EPA Reference: DOC20/607708-26

24 September 2020

**Proposed expansion of Fairfield Sustainable Resource Centre (Application SSD-8184) -
Corner of Hassall Street and Widemere Road Wetherill Park NSW 2164**

Designed: PS	Approved: - STEVE NOVAK		
Drawn: MR	Project Engineer/Director:	Date: 15/05/2020	
Scale: 1:1500	Project No:	Drawing No:	Issue
Date: APRIL 2020	PS102981	C070	C

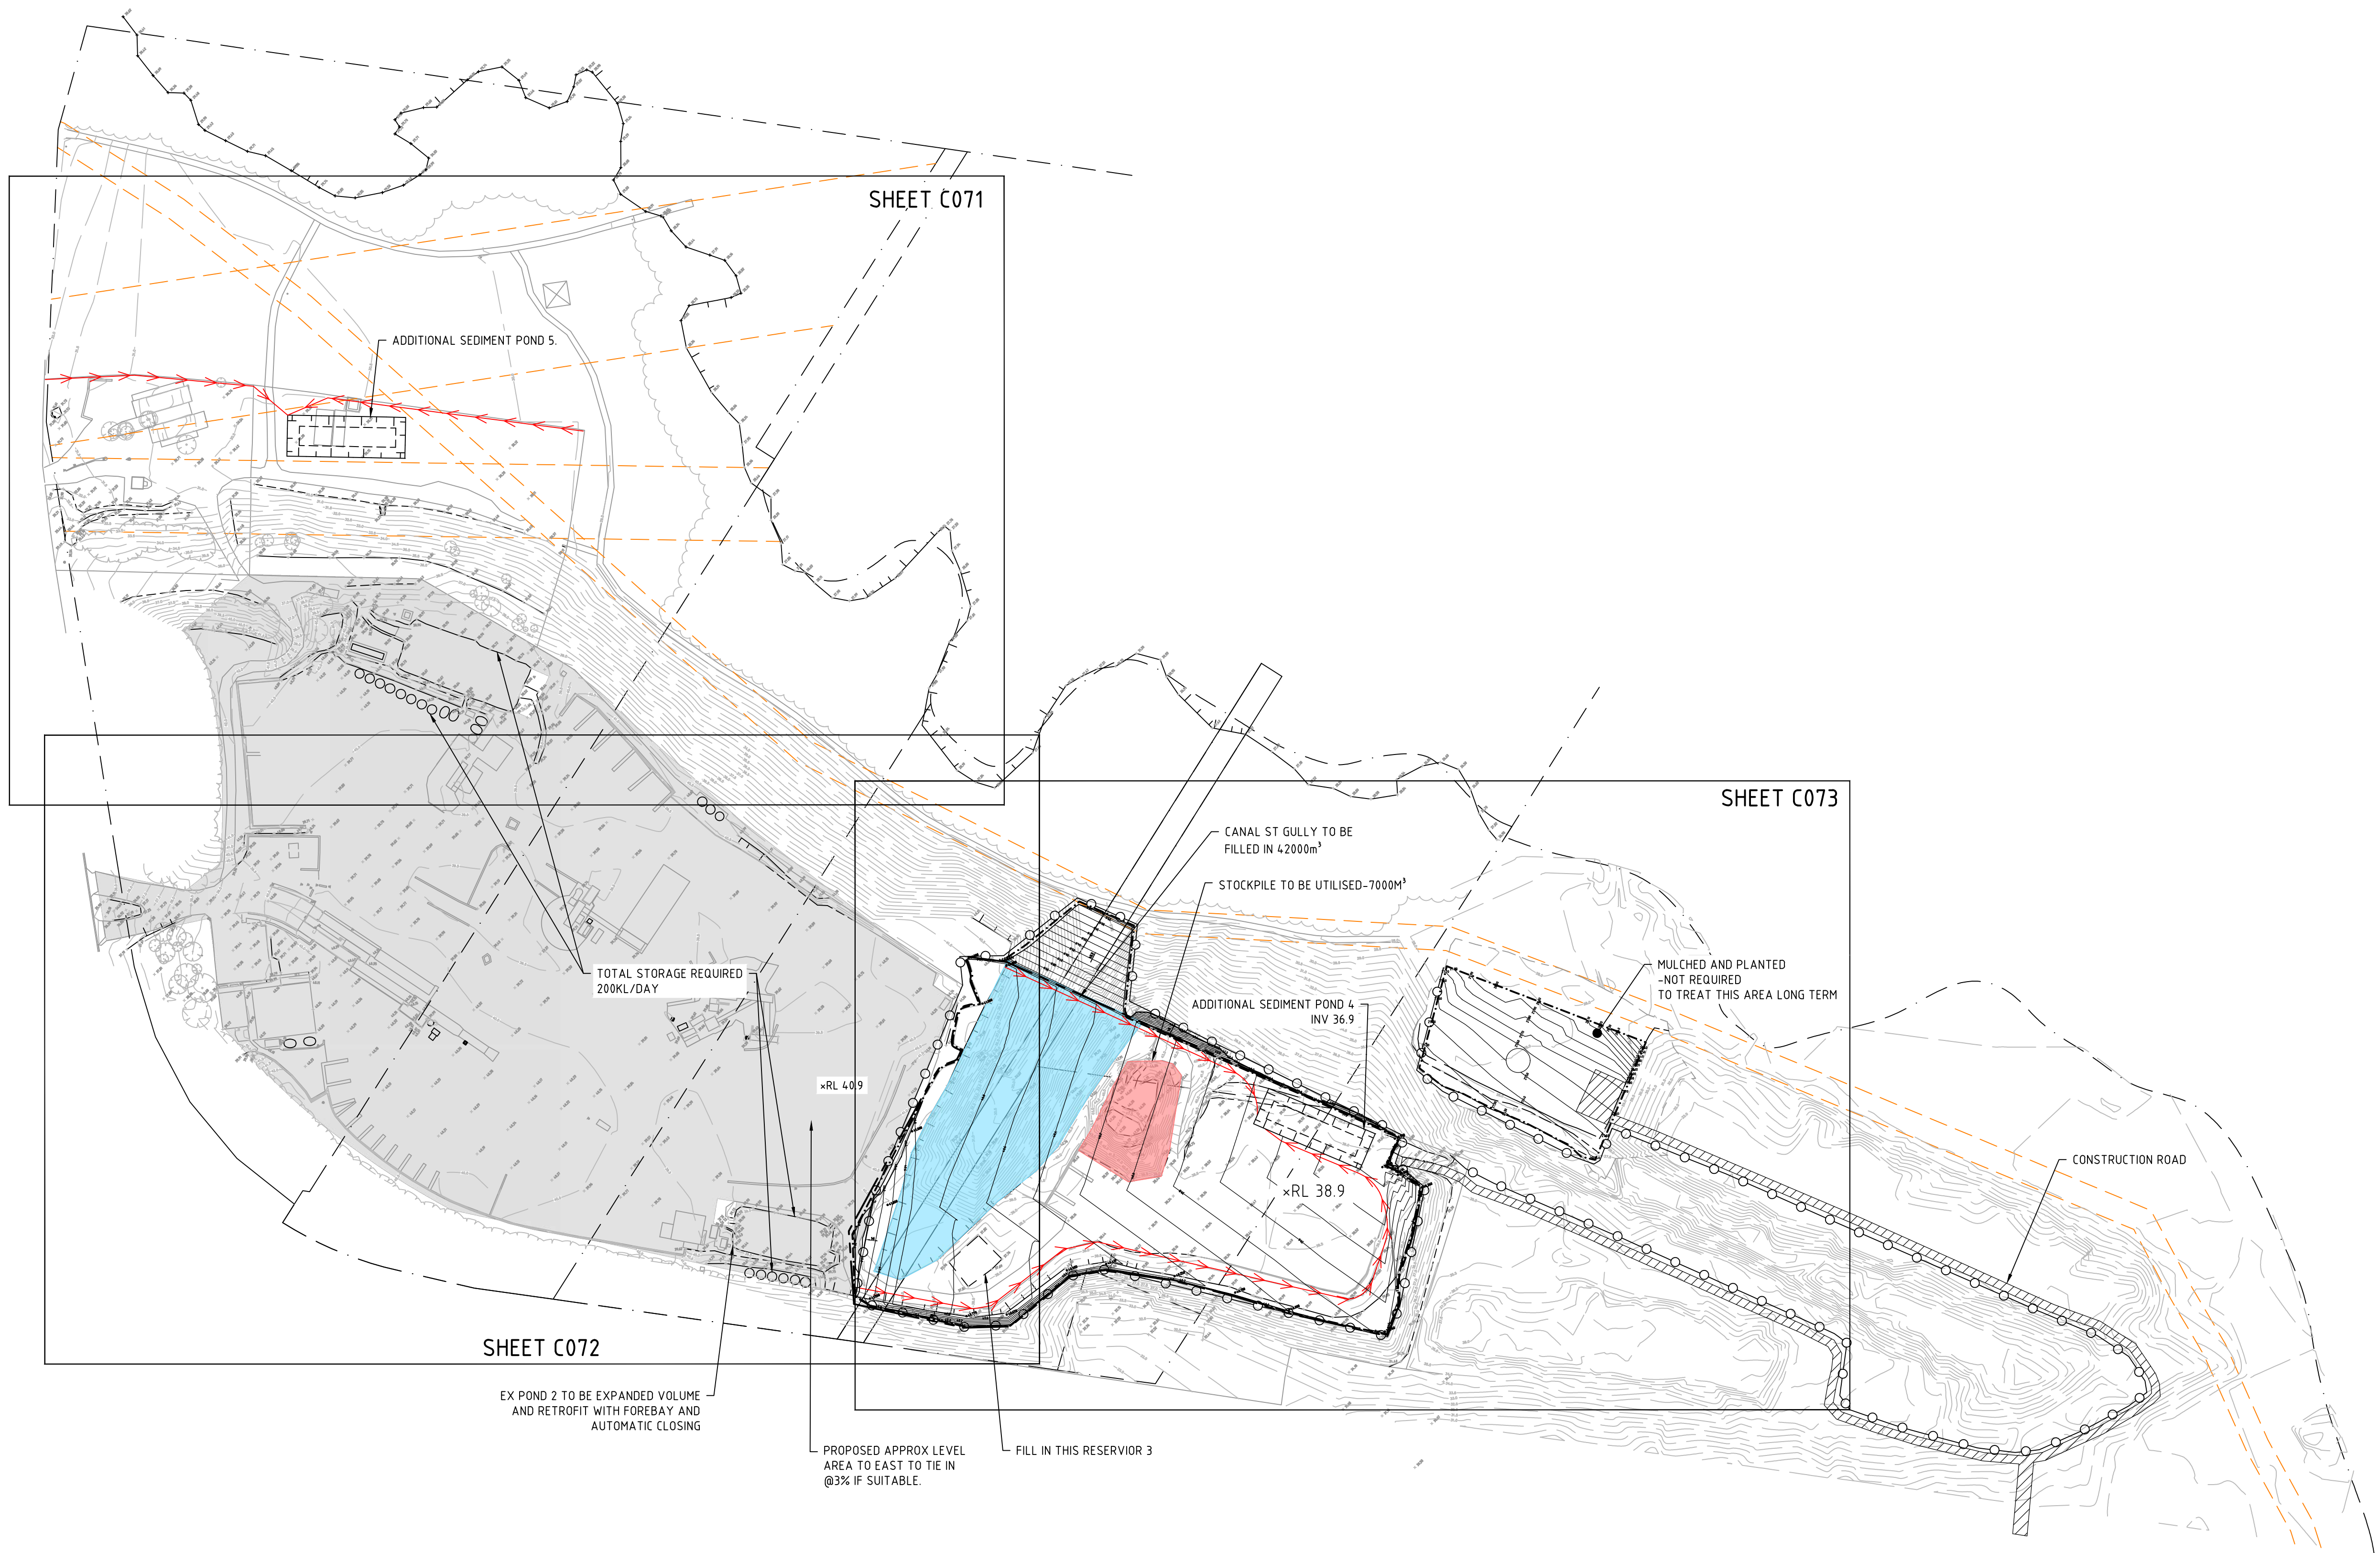
- That the Applicant commits to adopting enhanced erosion and sediment controls during the construction stage.

Appendix 6 of the EIS states the proposed development on the eastern end of the Premises would level and expand the operational areas, involving bulk earth works to infill Sediment Basin 3 and a gully that runs along the centre of the existing Premises. The EIS indicates that approximately 30,789m³ of fill material consisting of virgin excavated natural material, excavated natural material and potentially stockpiled material would be used for the infilling works.

The EIS states that during construction, erosion and sediment controls to be implemented would include sediment fences around the proposed expansion areas on the north-west and eastern end of the Premises and downstream of batters and stockpiles. Given the duration and extent of the disturbance, the fact that the Premises is raised approximately 5-10m above the surrounding areas, and the proximity to Prospect Creek, enhanced erosion and sediment control measures should be implemented. This could include, for example, practices and principles consistent with *Managing Urban Stormwater Soils and Constriction Volume 2E Mines and Quarries* (DECC, 2008).

Designed: PS	Approved: - STEVE NOVAK	 North
Drawn: MR	Project Engineer/Director:	
Scale: 1:1500	Project No:	
Date: APRIL 2020	Date: 15/05/2020	
	Drawing No:	Issue
	PS102981	C075
		C

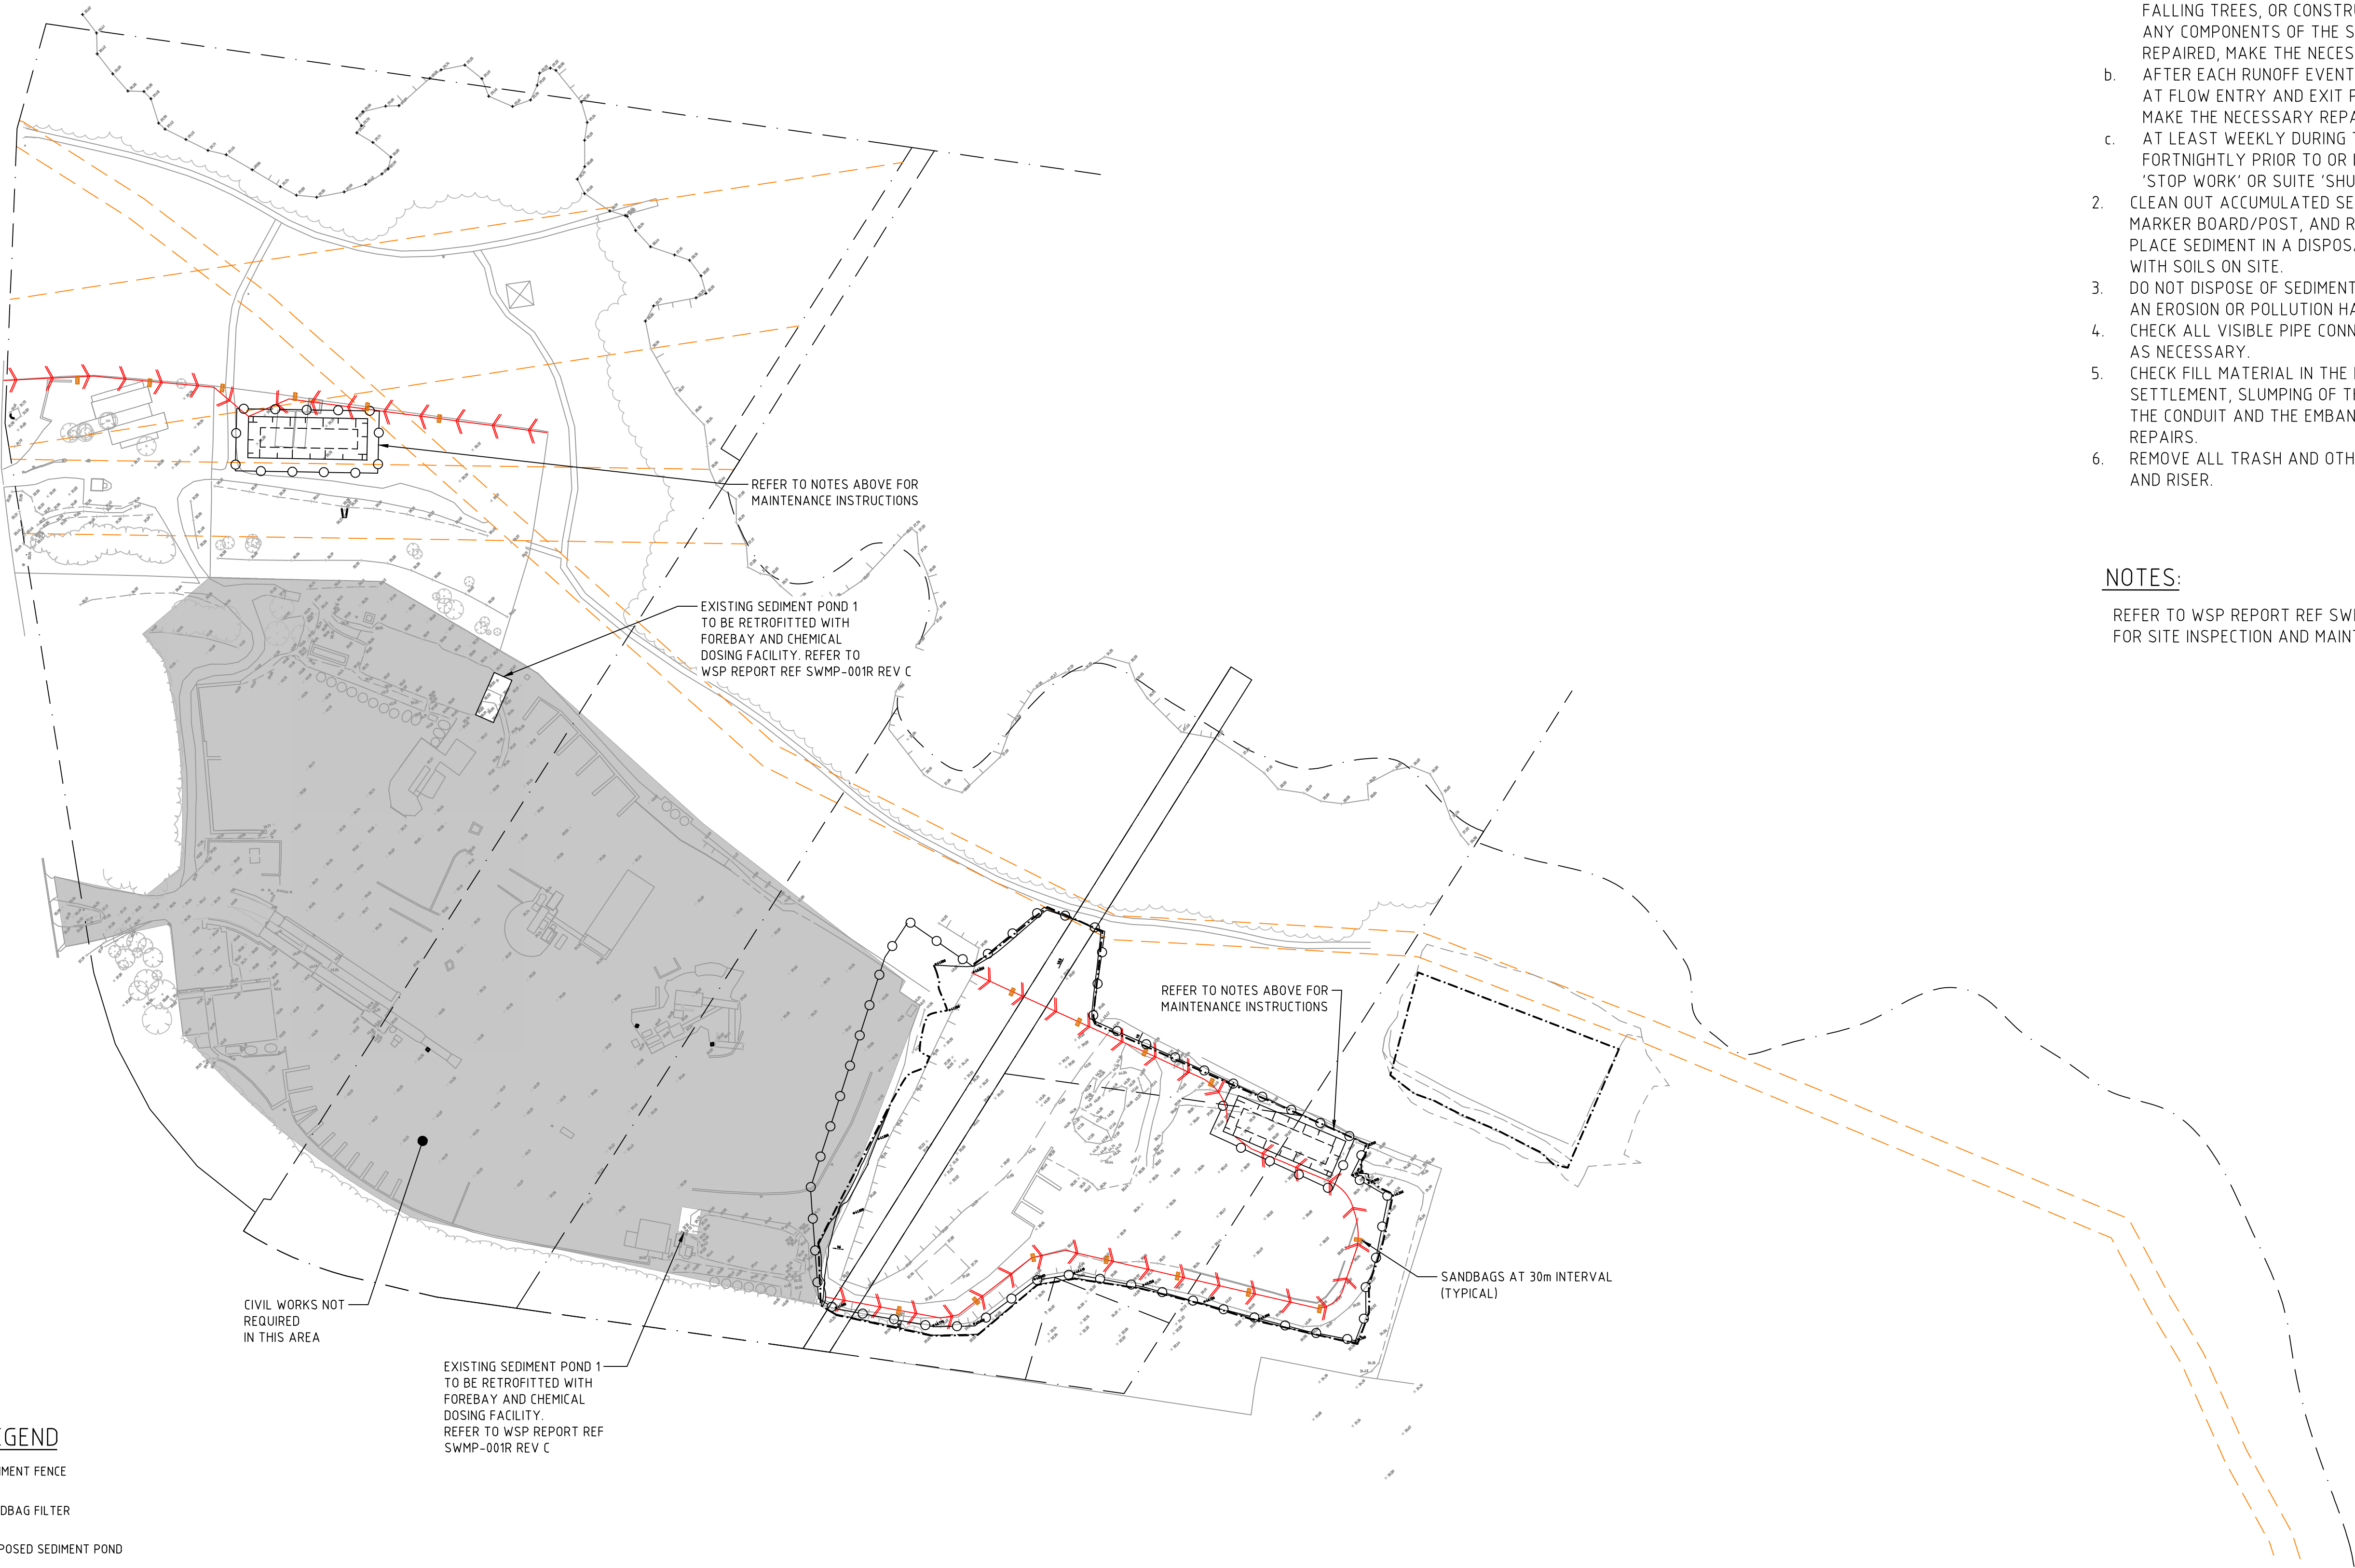
- That the Applicant provides details of the expected frequency, volume and the design storm criteria for all the sediment basins at the Premises when managed overflows would occur.

The EIS states in the event of a large storm, overflows from the sediment basins would sheet flow approximately 100m overland to Prospect Creek. However, the water balance provided in the EIS does not detail the “large storm” rainfall event, expected frequency and volume of managed overflows that would occur for each of the four sediment basins.
